# CITY OF ALBUQUERQUE

October 4, 2017

Kevin Patton, Pulte Homes of New Mexico, kevin.patton@pultegroup.com  
Michael@superiorstormwater.com  
Site: Glendesto

**Re: Drainage Ordinance (14-5-2-1) Violations for Erosion and Sediment Control and Pollution Prevention**

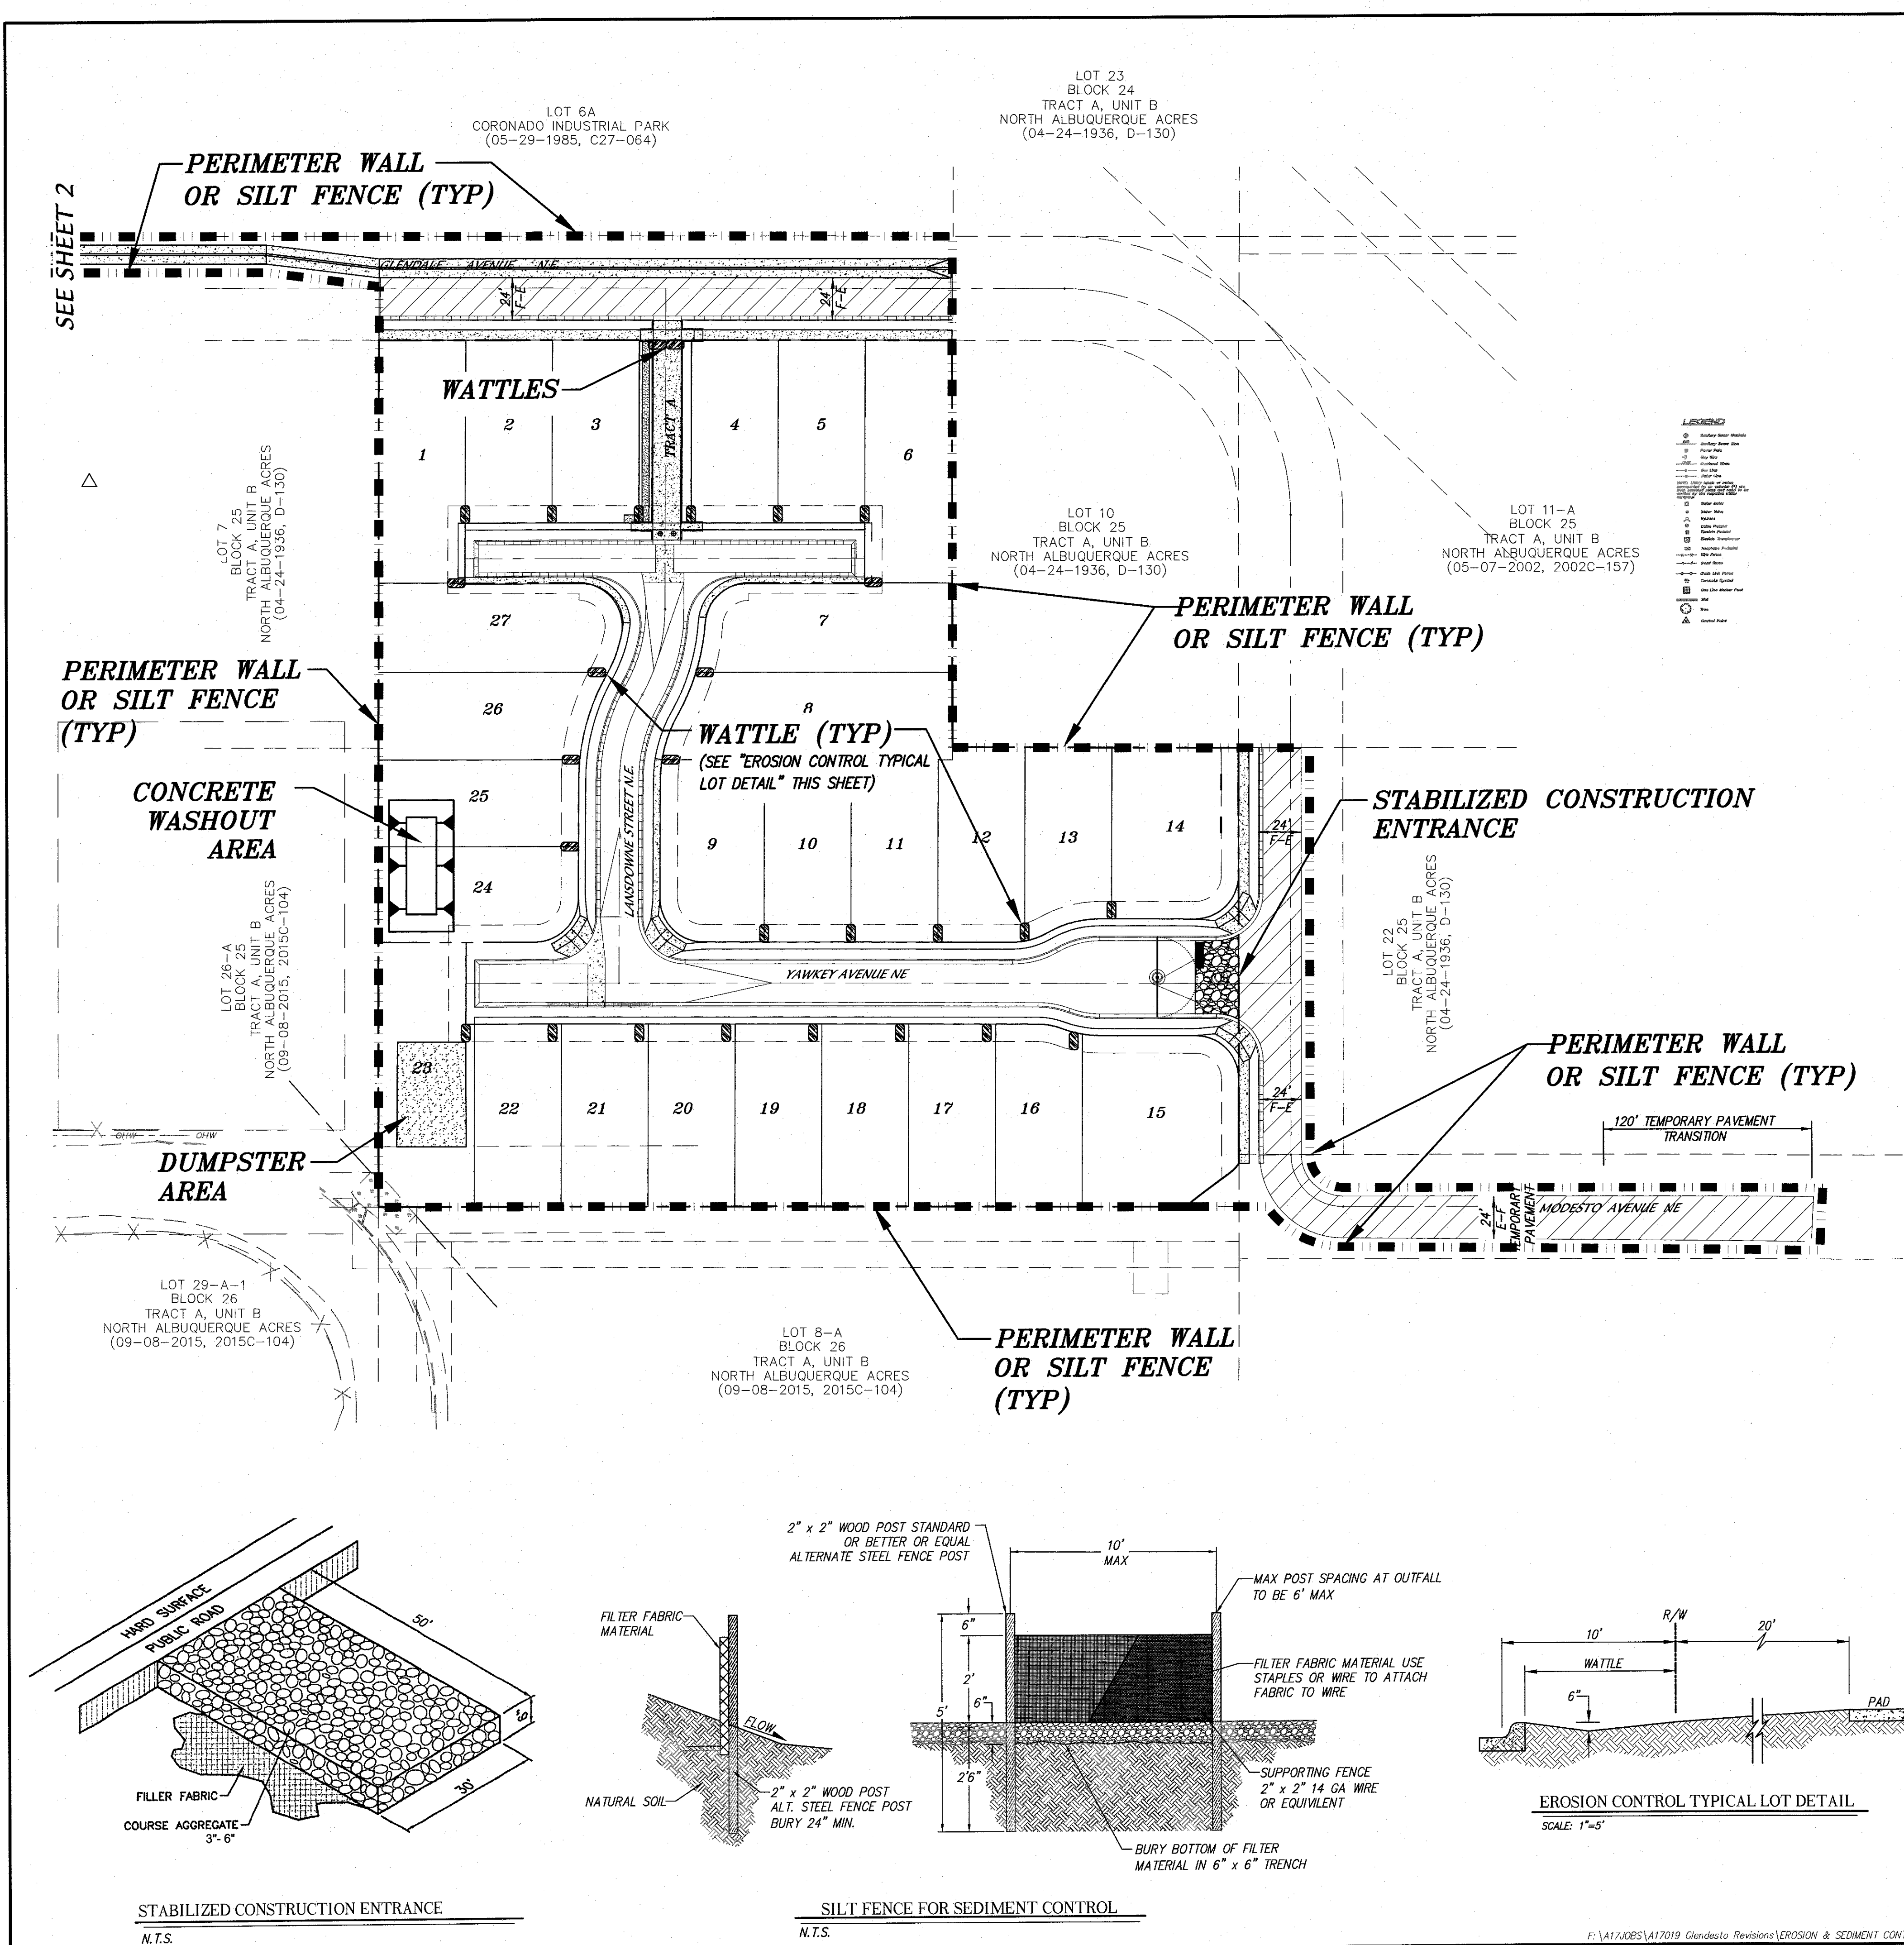
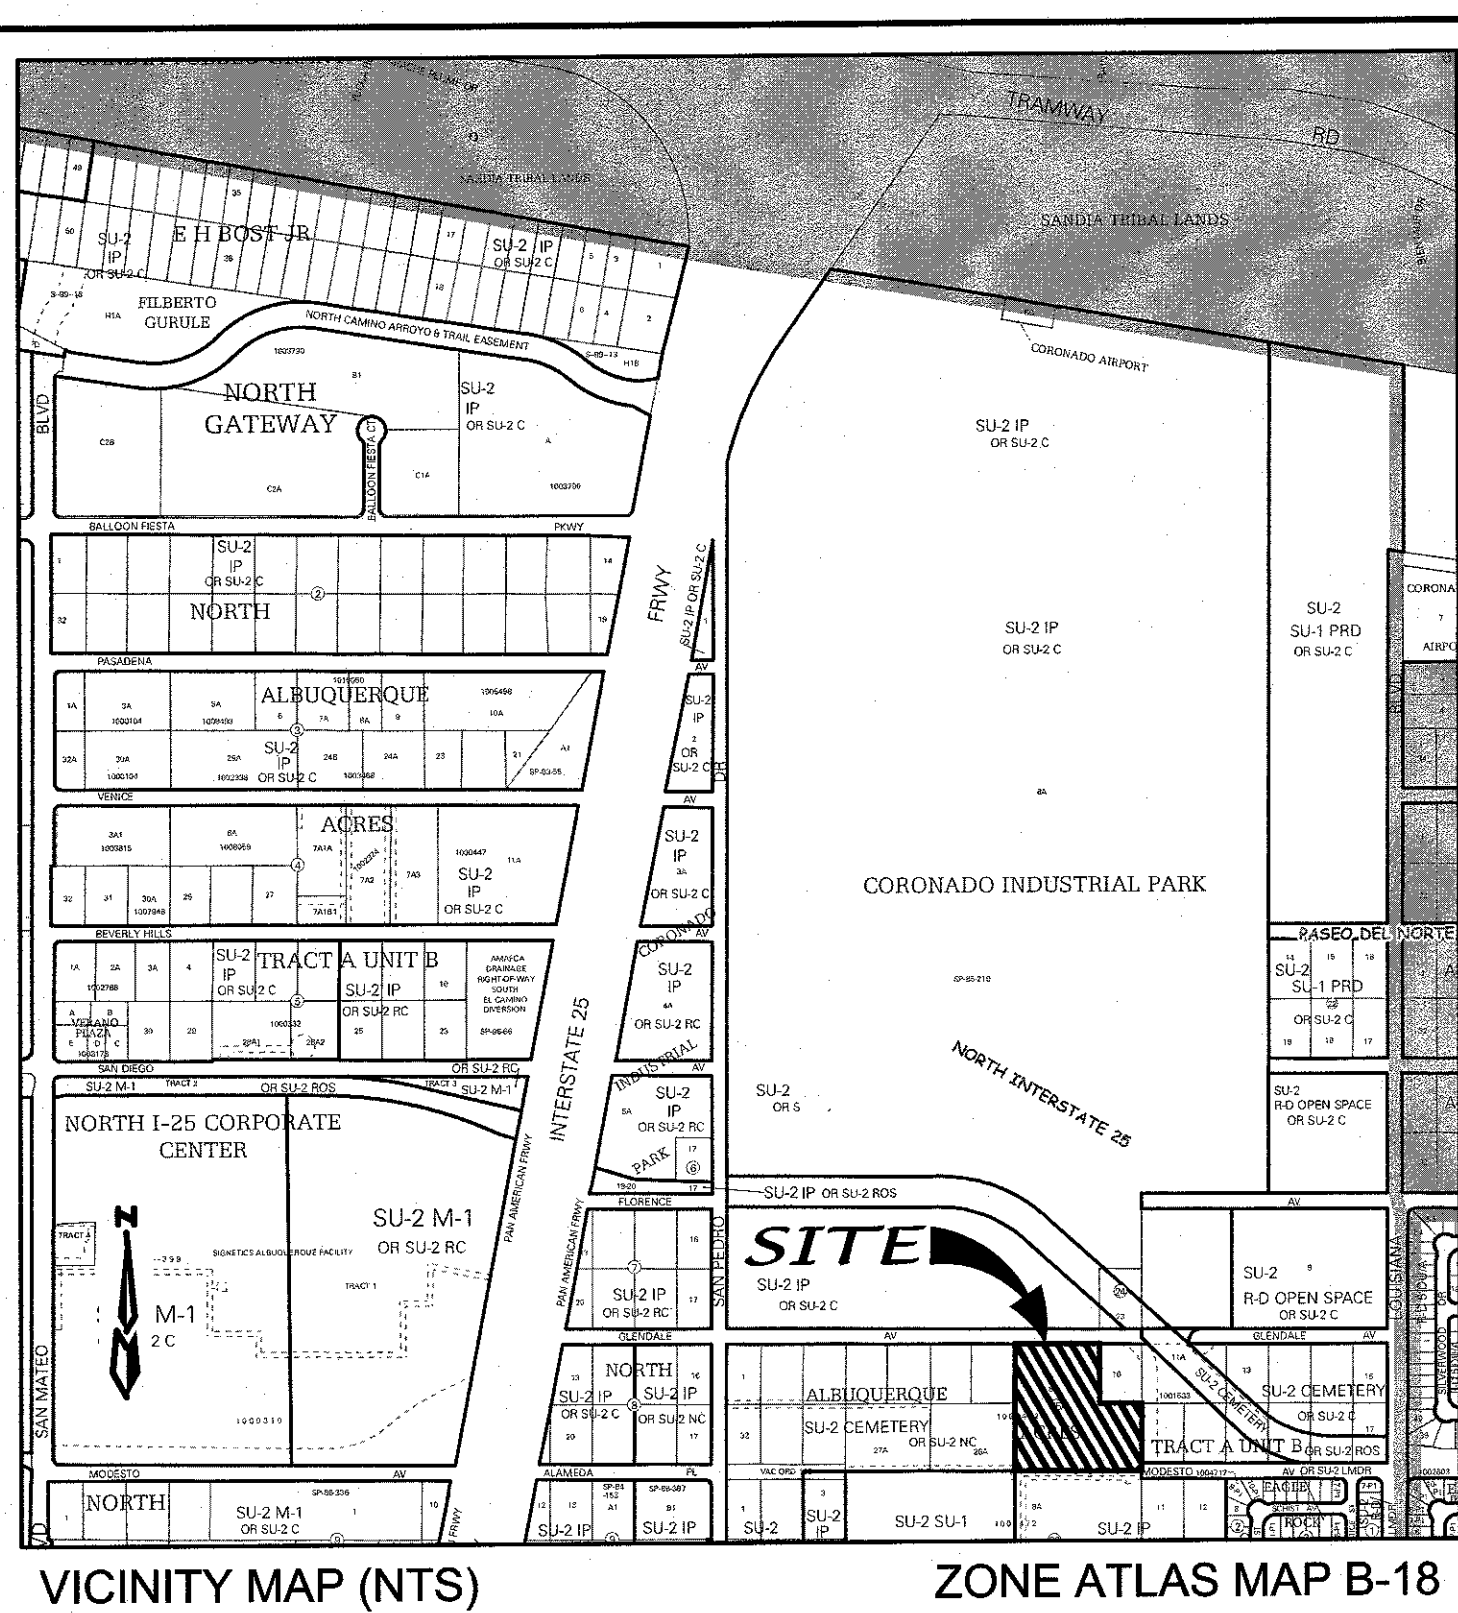
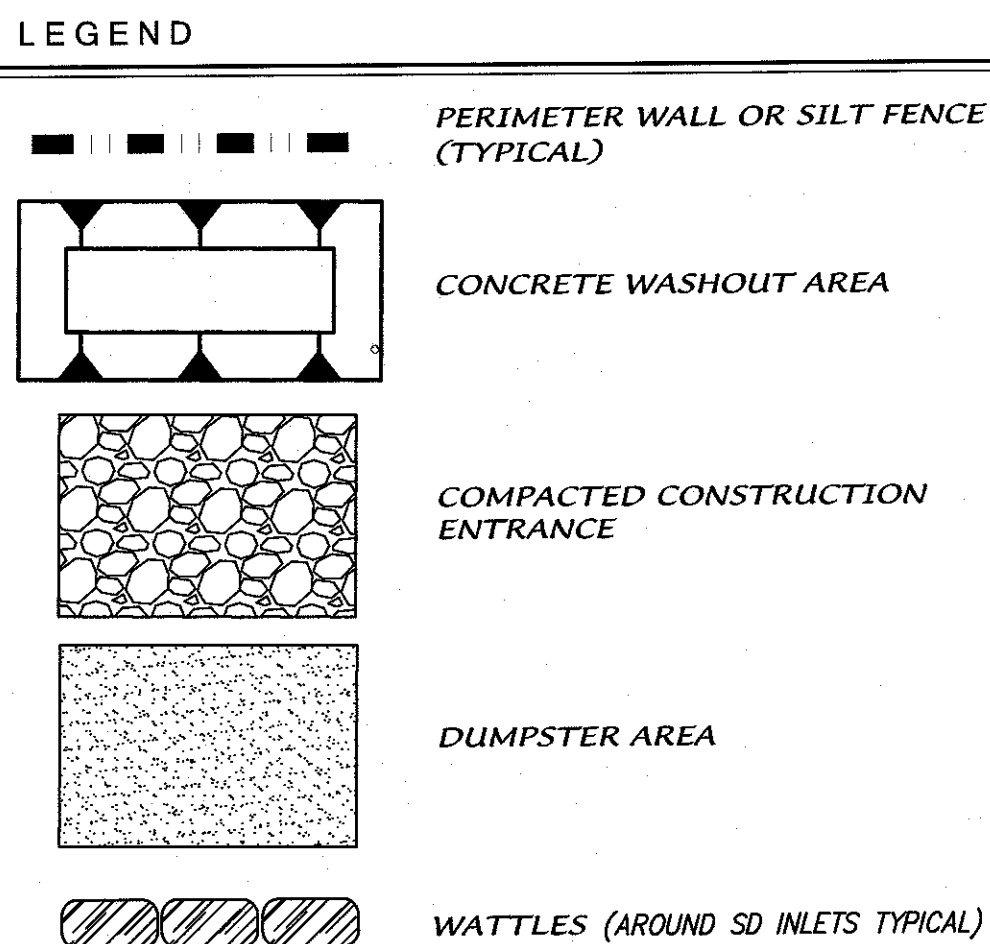
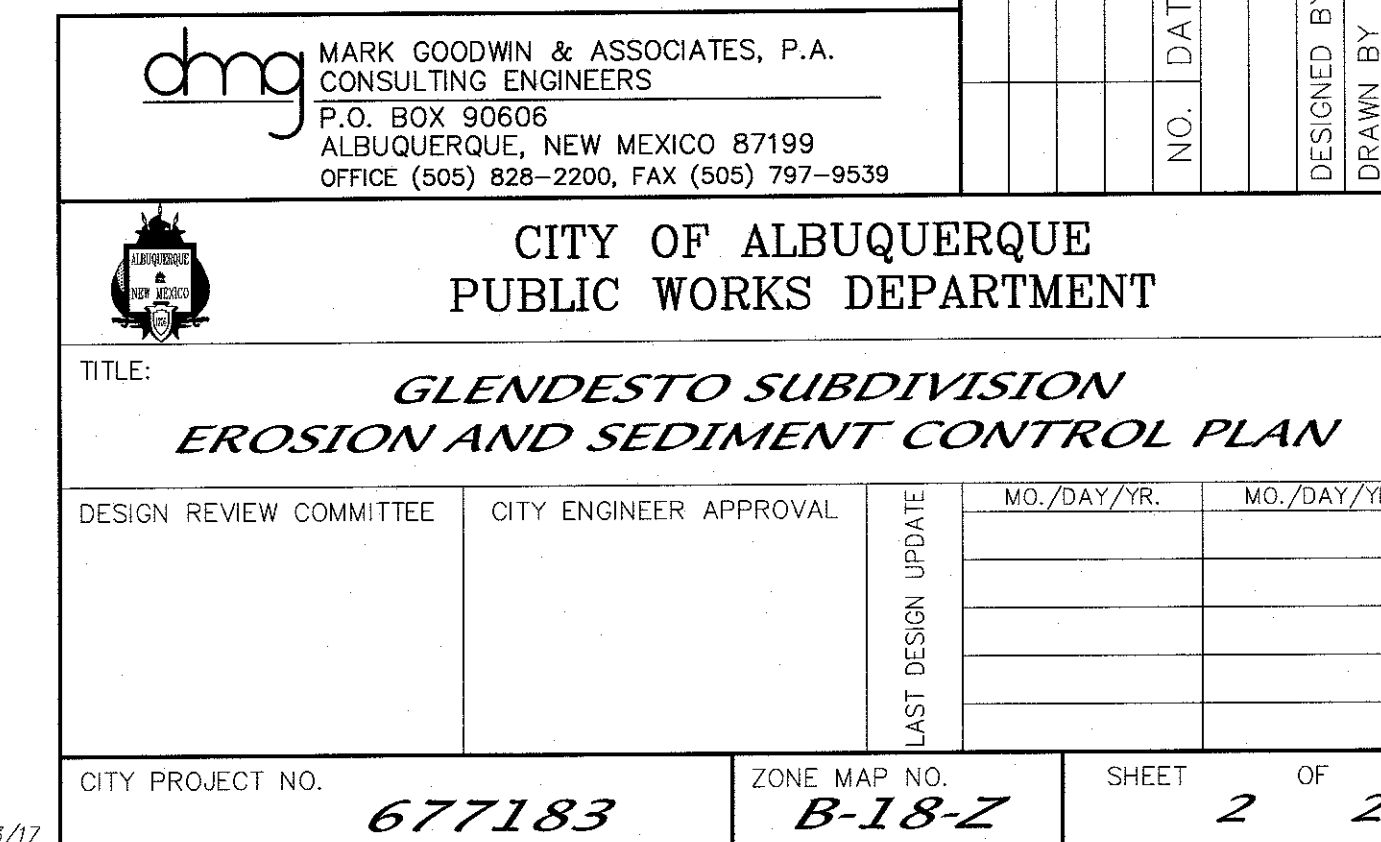
1. The site was being graded and there were no BMPs installed.
2. There was no chemical toilet.

1. Install BMPS per approved Erosion and Sediment Control Plan with an additional requirement that if grades remain as they exist today a sediment pond or second layer of sediment control is required in the southwest corner as it an outfall.
2. Bring in a chemical toilet.
